Peerless Farms

Preliminary Plan, Pre-Development Site Grading & Wet Utilities Letter of Intent

SF-21-7

PRELIMINARY PLAN
SHEET 2 OF 3

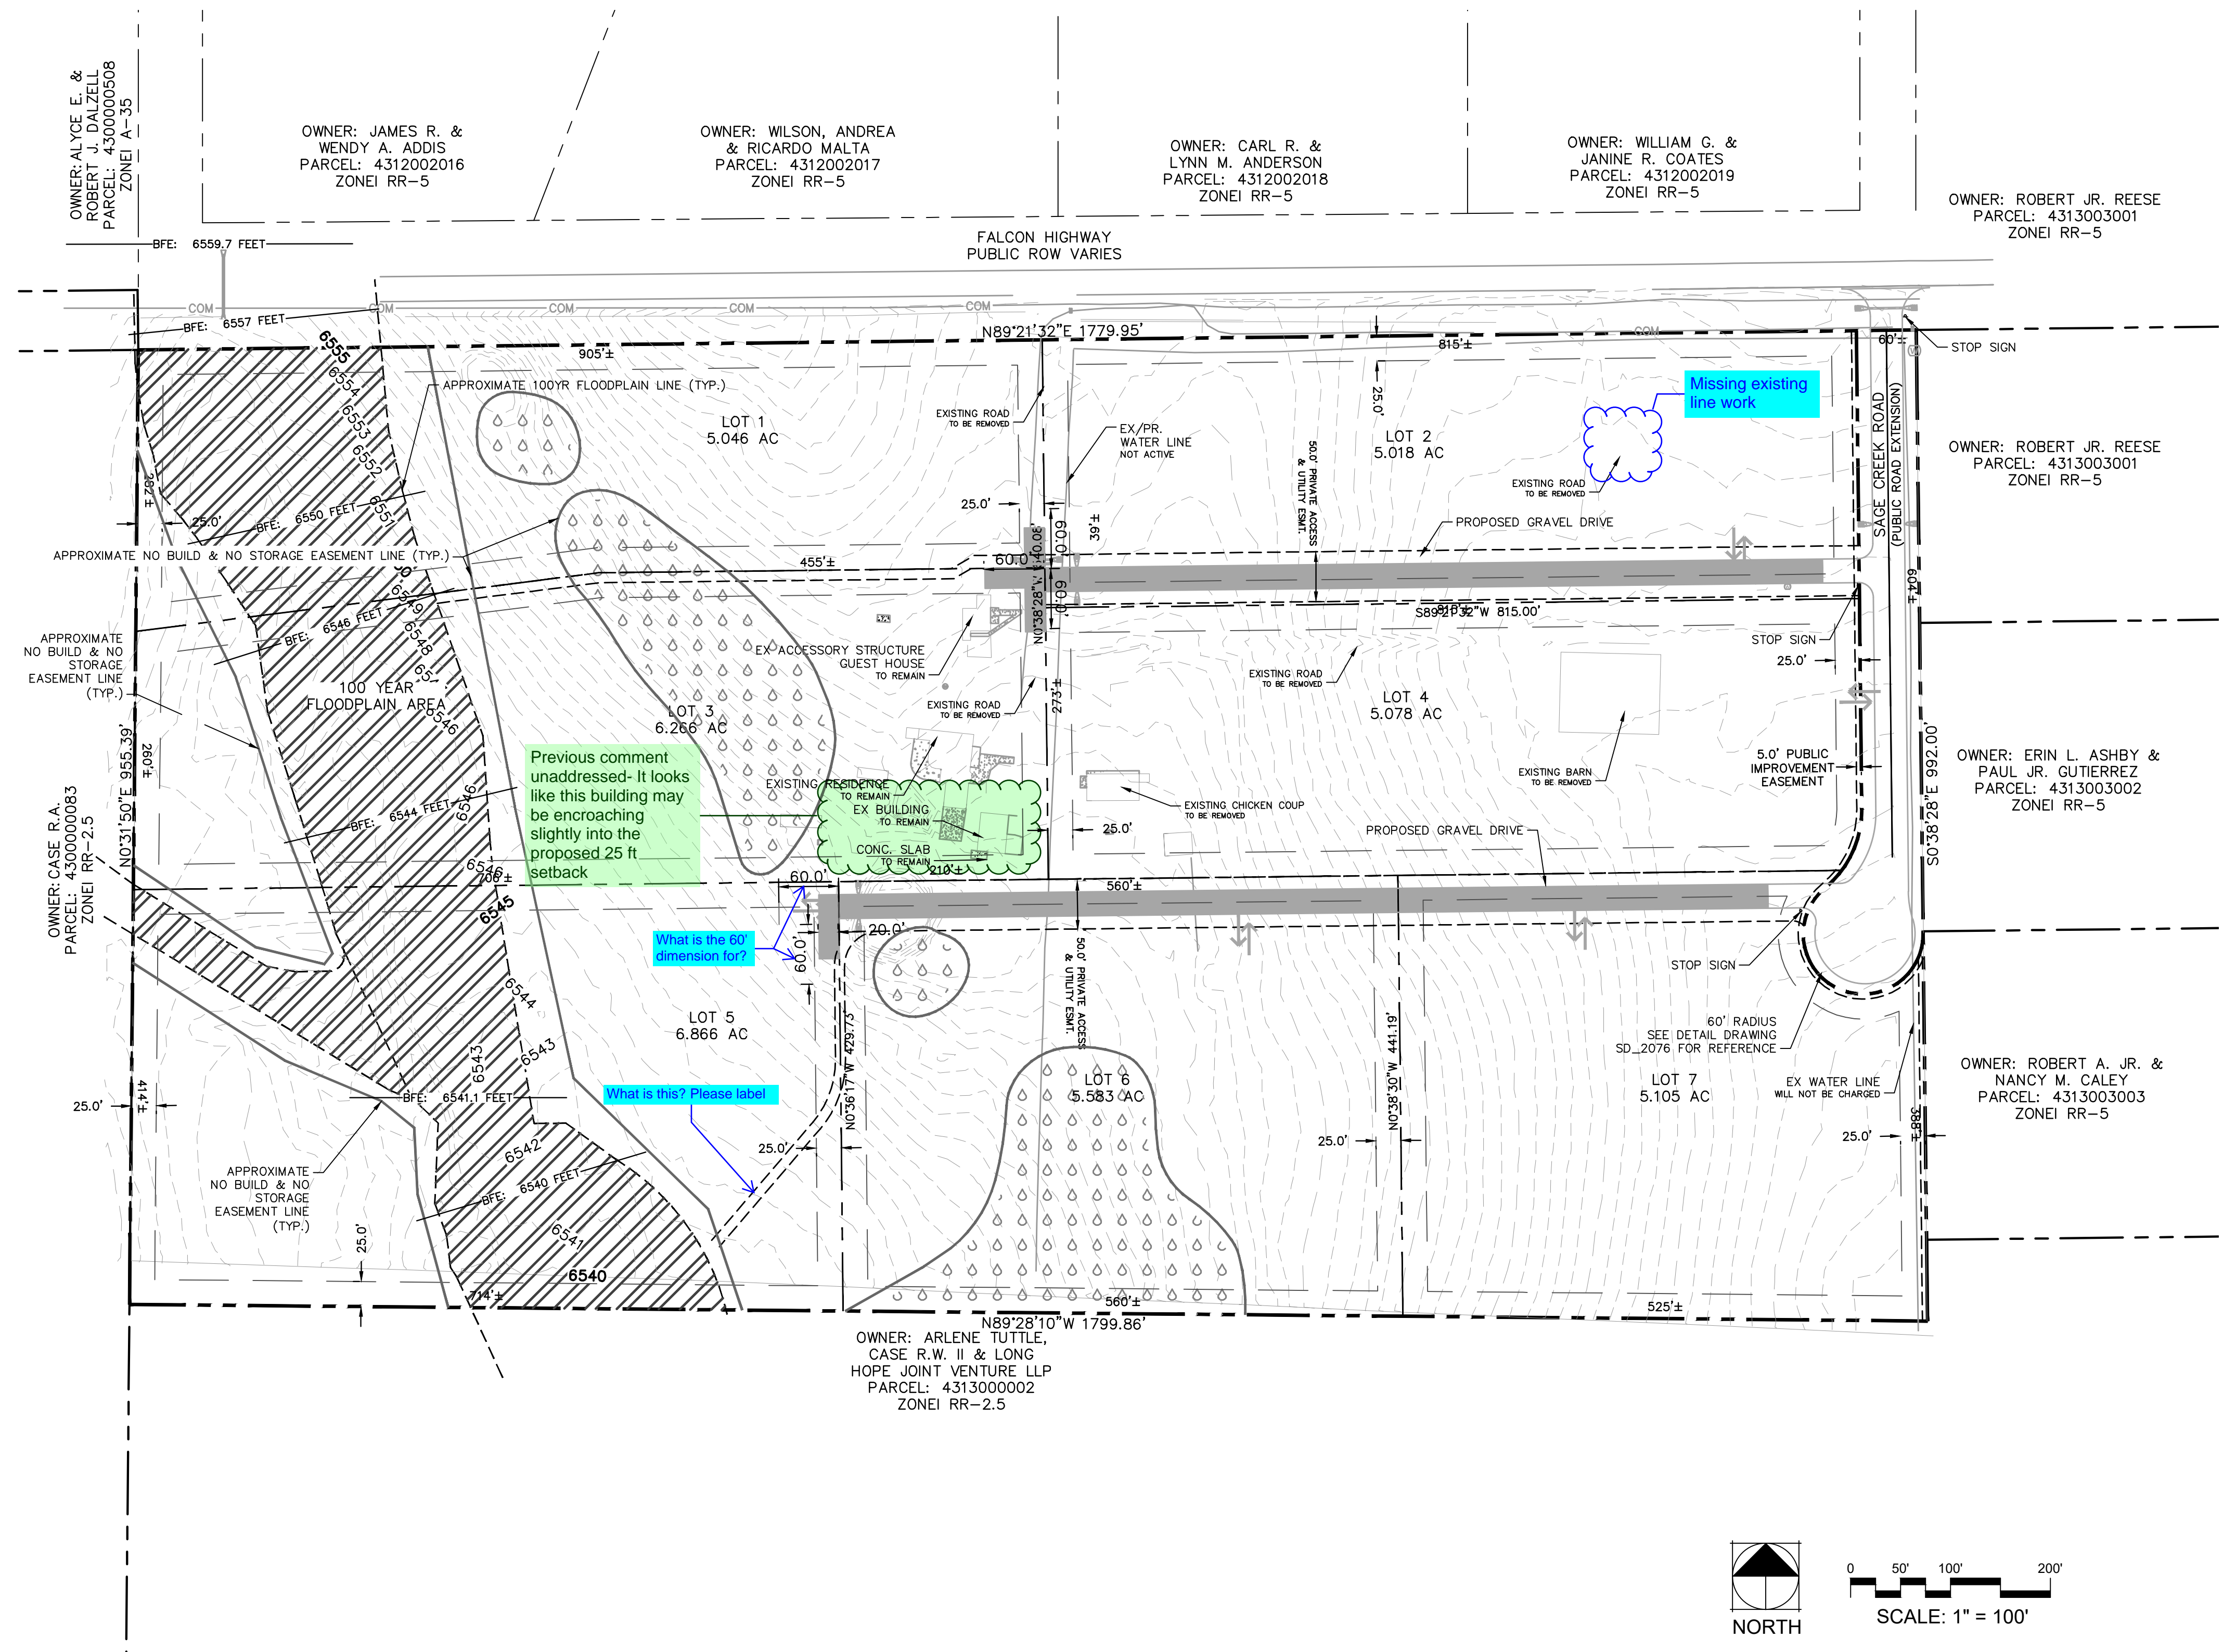
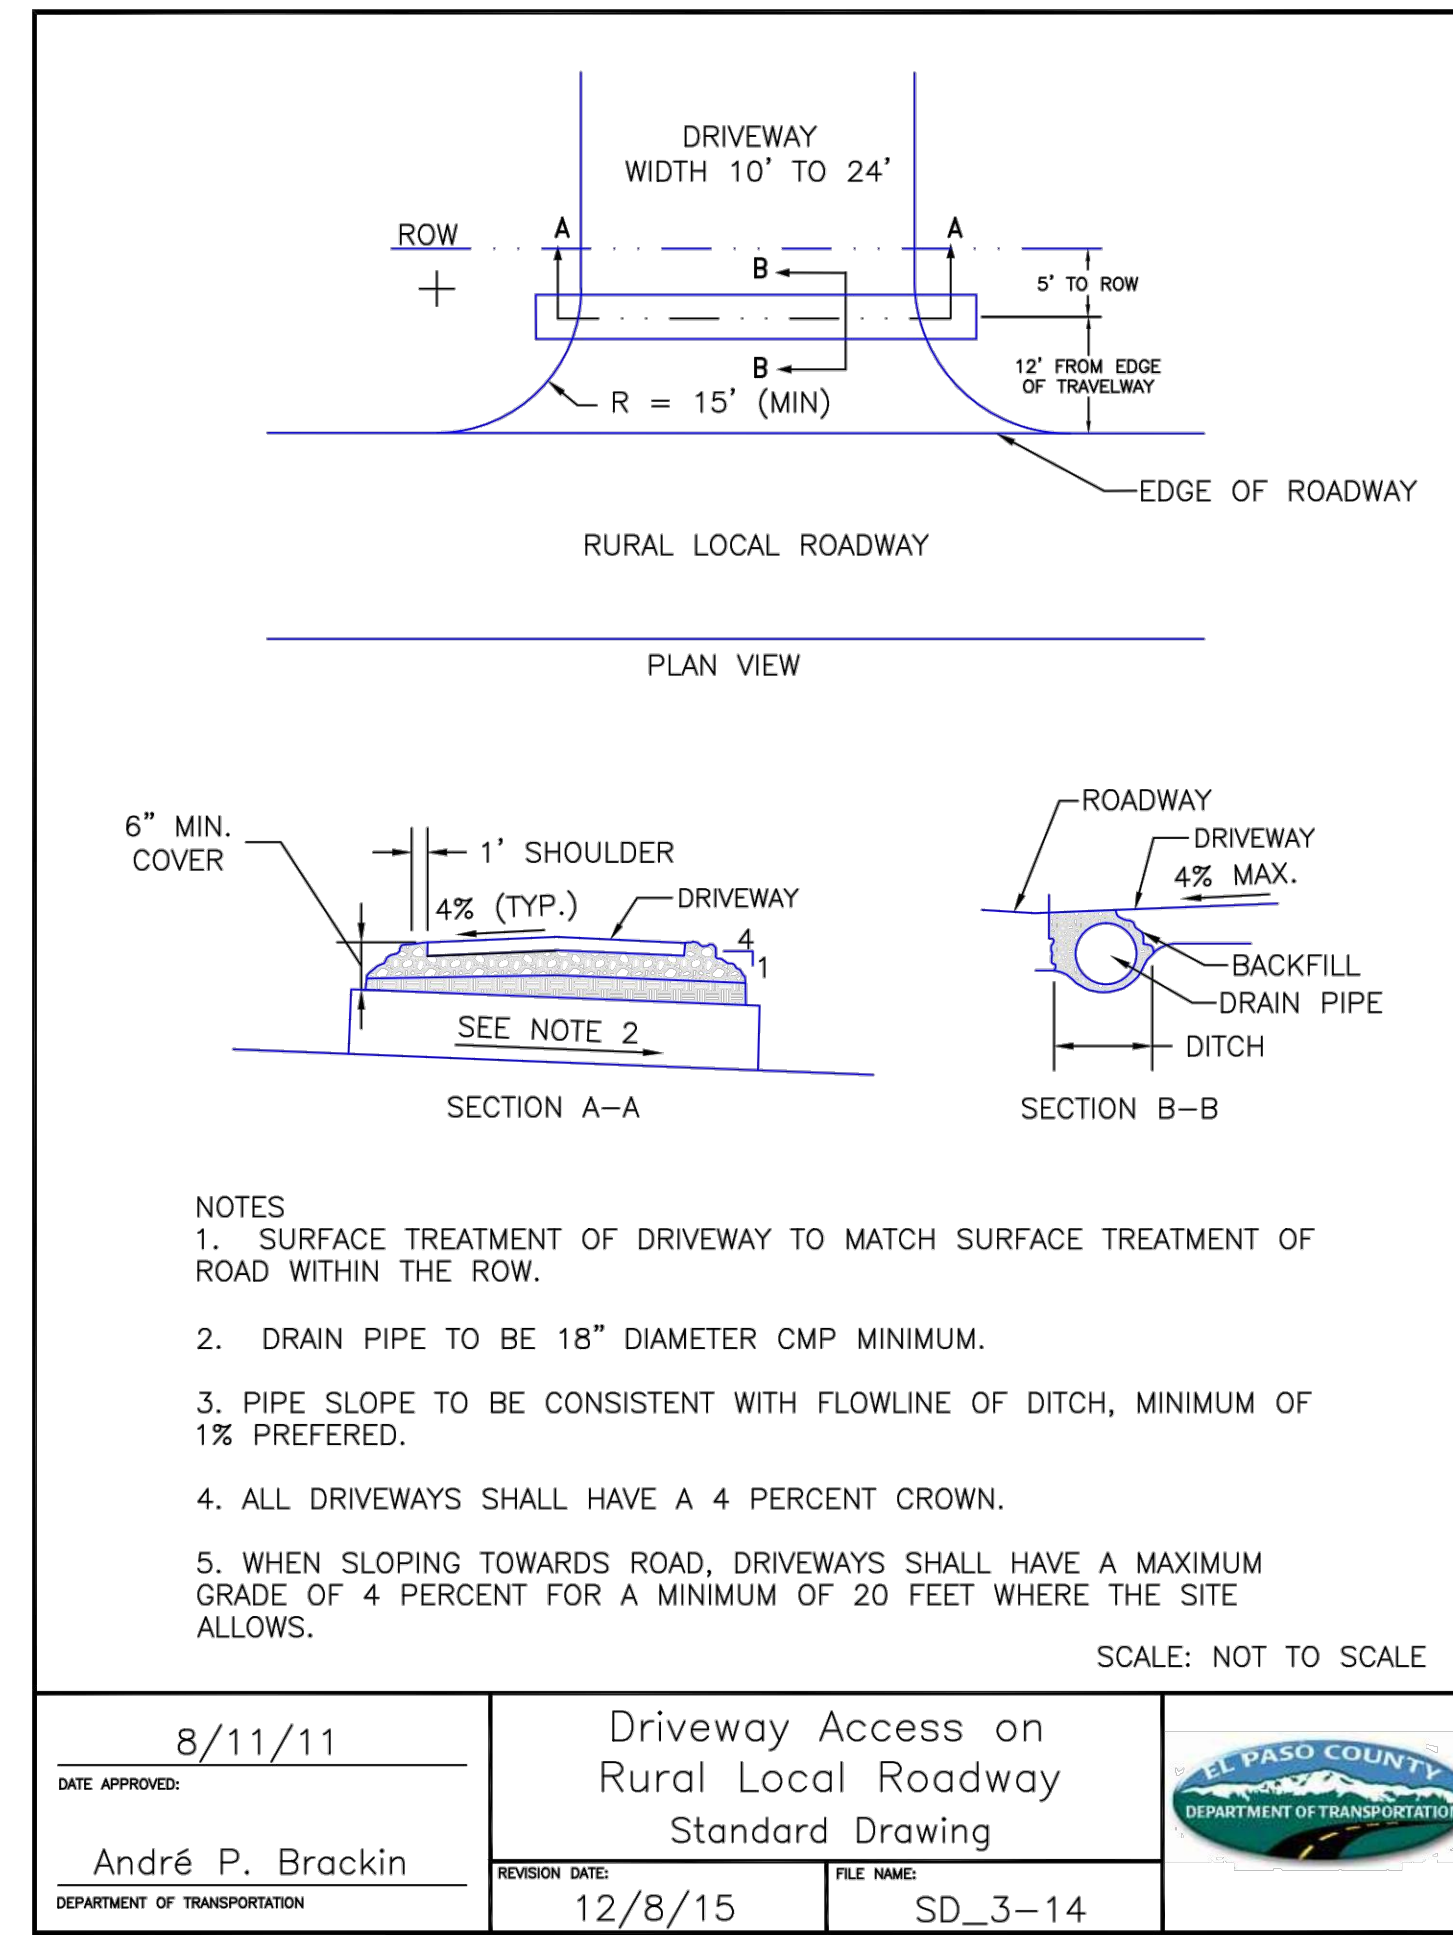
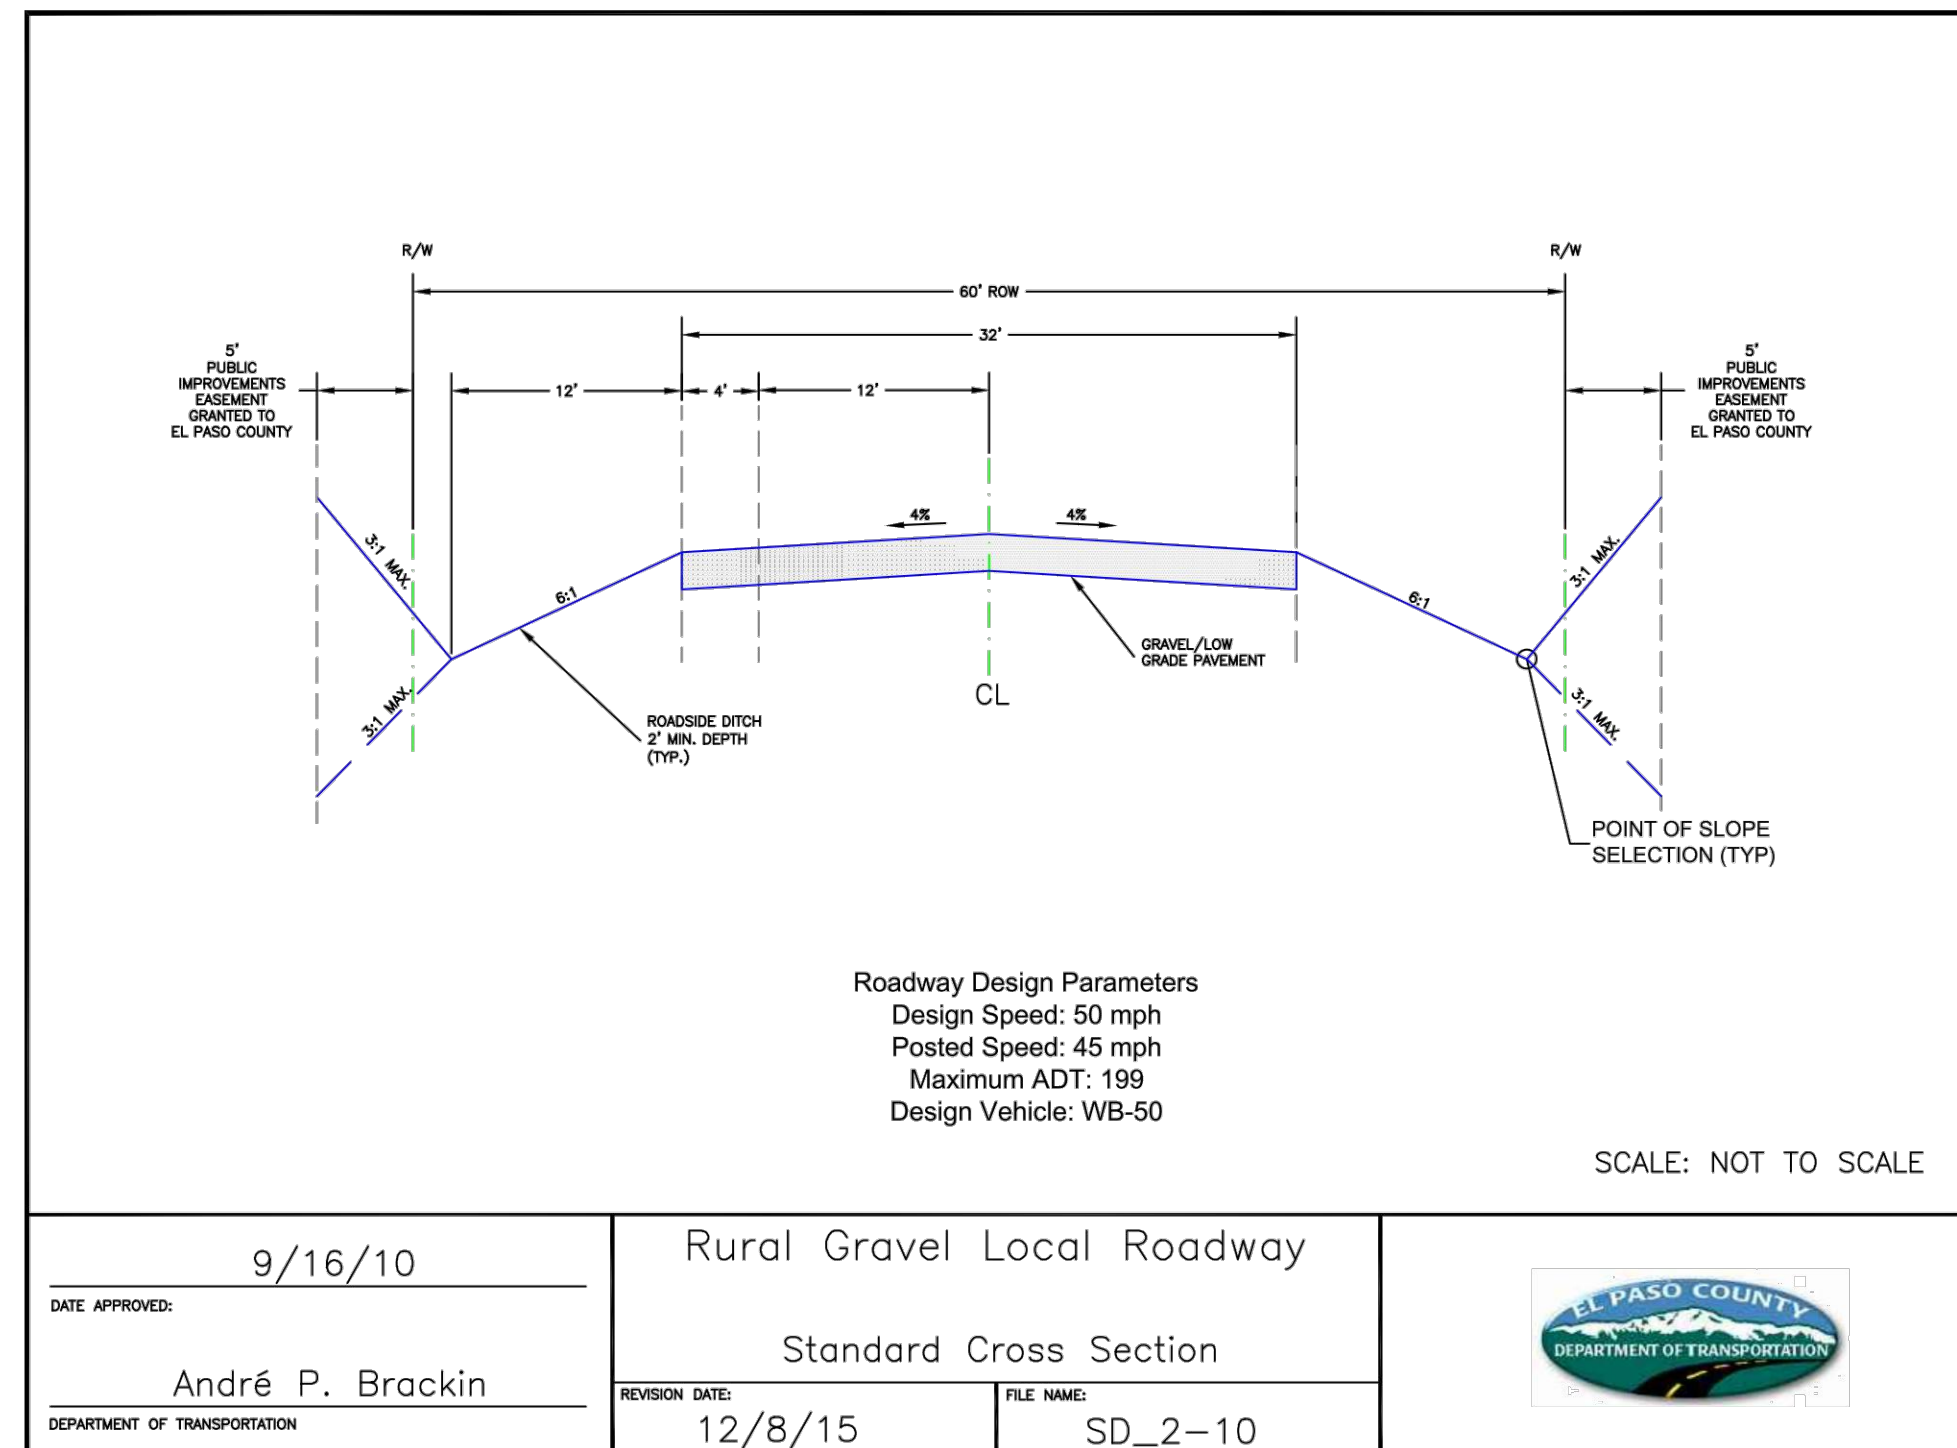
Please explain why there are two residences on the proposed Lot 3. We cannot approve a subdivision that will create a nonconformity. If both of the dwellings have existed since prior to zoning, please explain.
